DEVELOPMENT HEARING OFFICER

Planning - Case Comments

Project Number: PR-2019-2284 AKA 2018-001774

Project Name: Andretti's Racing

COLORED ELEVATIONS NORTH/SOUTH

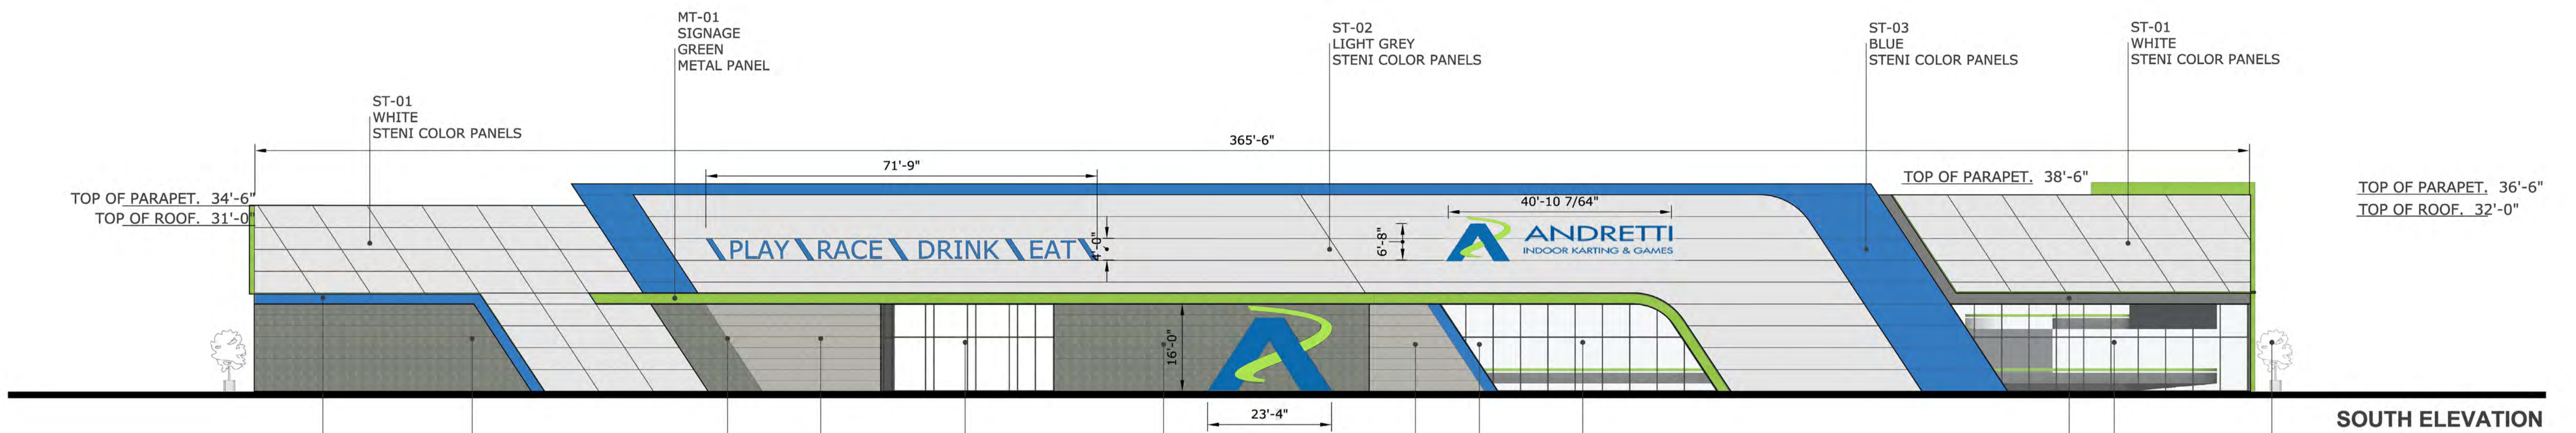
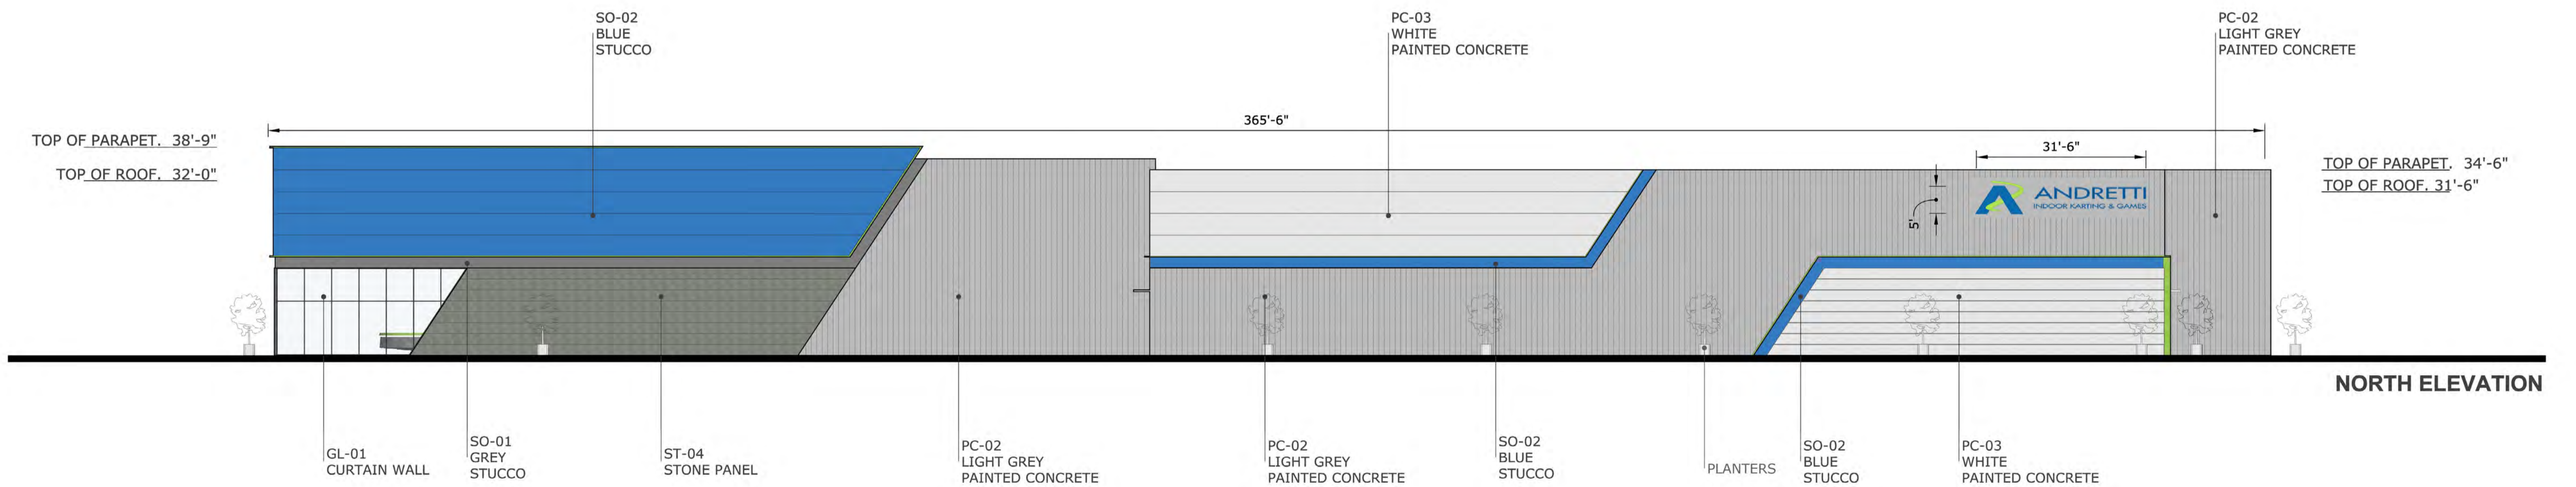
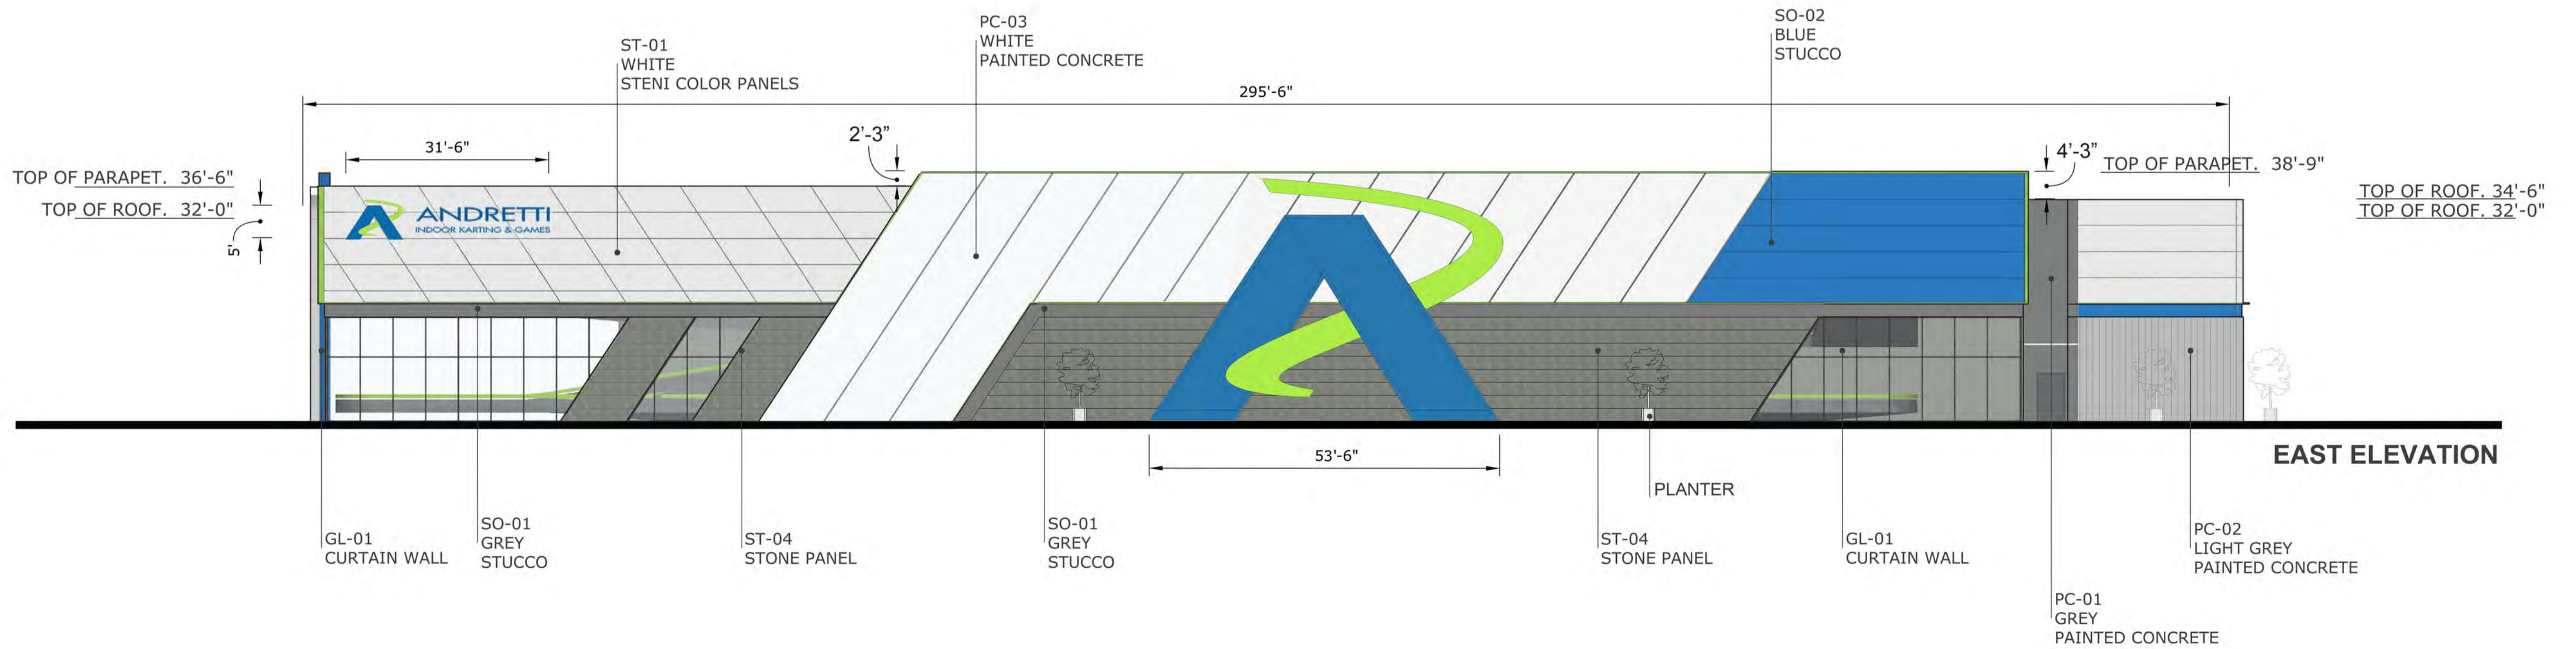
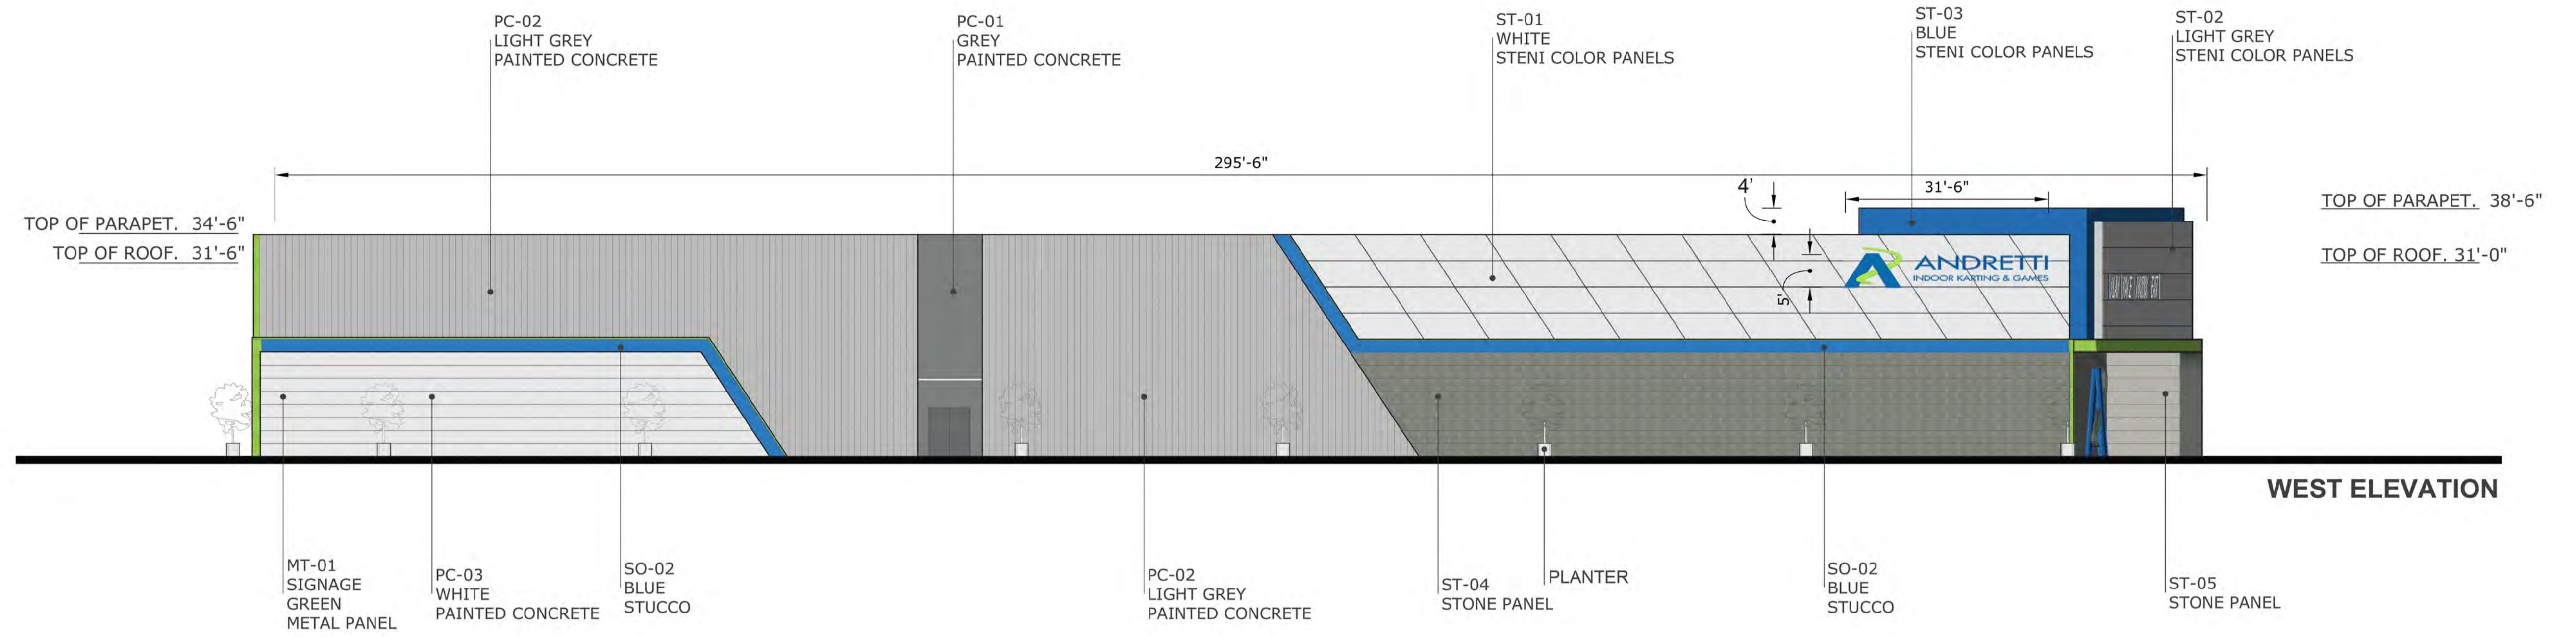
- A memo from the EPC Planner indicates that the building is 9 inches taller than allowed in the zone and recommended a determination be considered by the DRB (now the final sign-off is per the Development Facilitation team as of 12.25.22). **The applicant needs to submit a deviation request and the justification per IDO 6-4(O)(3) for the building to exceed the 38-foot maximum for the zone.**

Plat of
Parcel B-1-A-1
Renaissance Center III
Elena Gallegos Grant
Projected Section 34, Township 11 North,
Range 3 East, N.M.P.M.
Albuquerque, Bernalillo County, New Mexico
November 2022

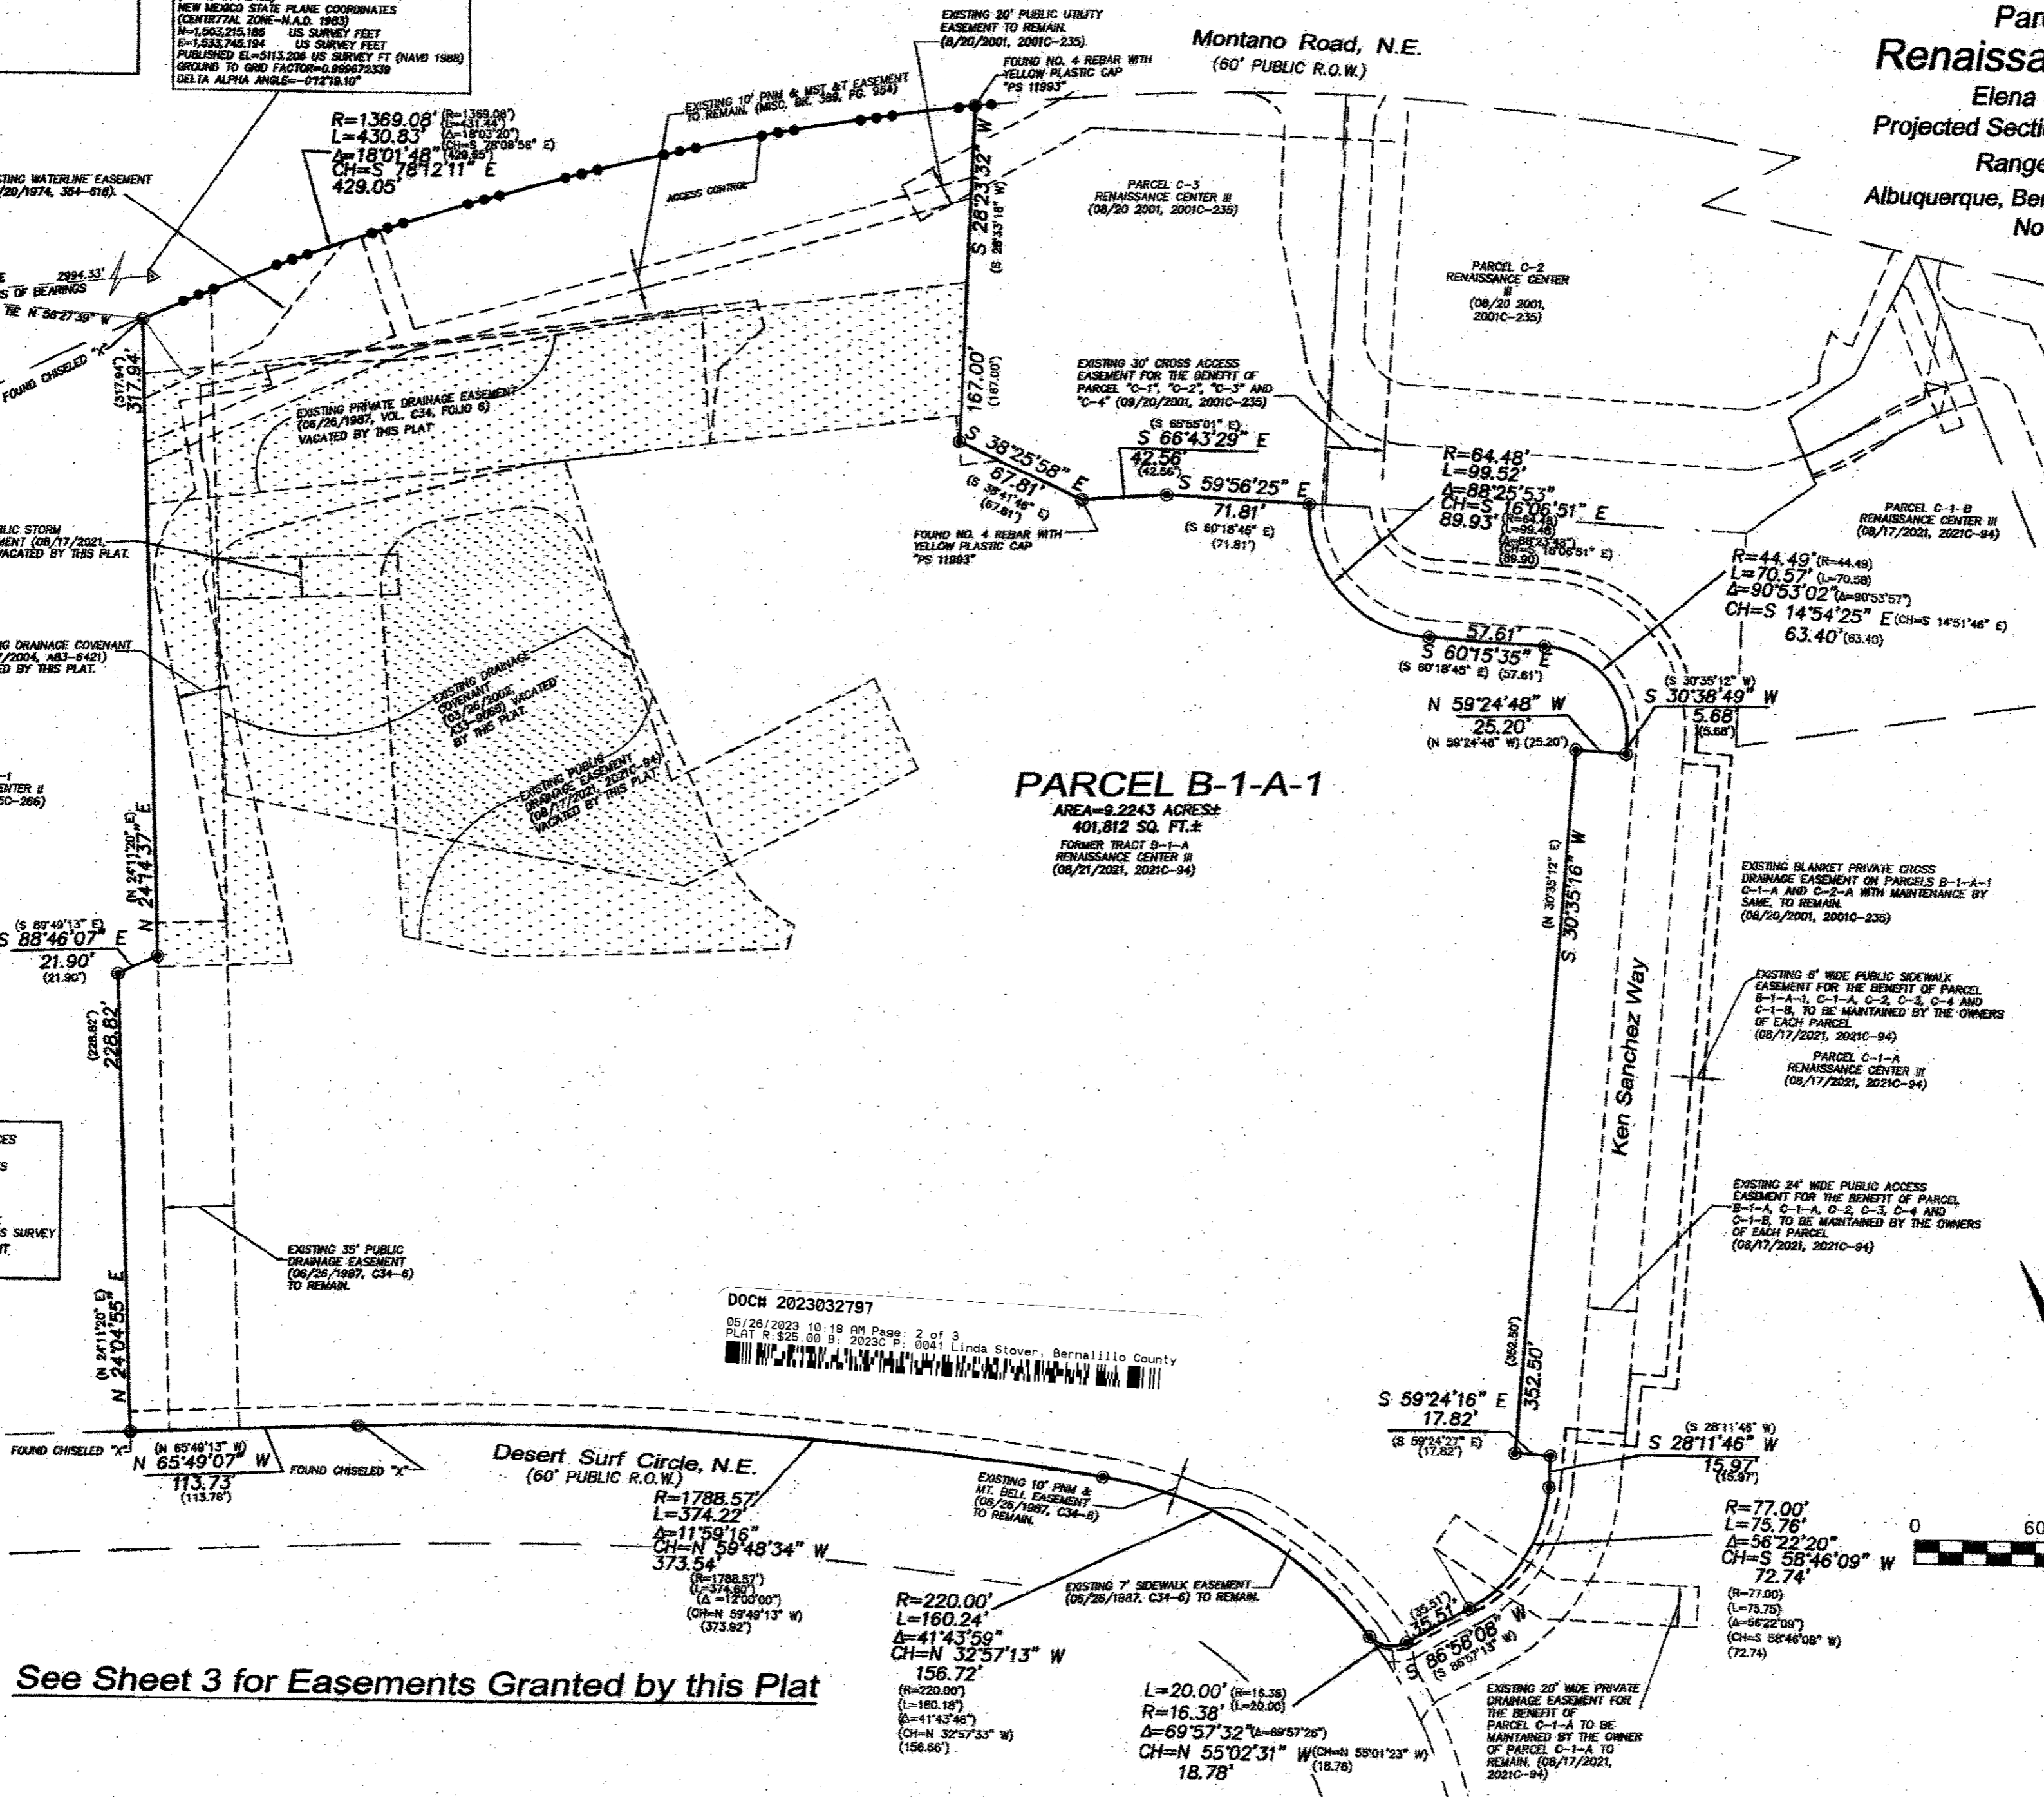
1. Prior to final signature:
 - a. Please confirm the location of the existing waterline and ensure it is within the existing easement shown on the plat.
 - i. If the easement shown is not adequate, please provide an additional easement as needed for the existing waterline.
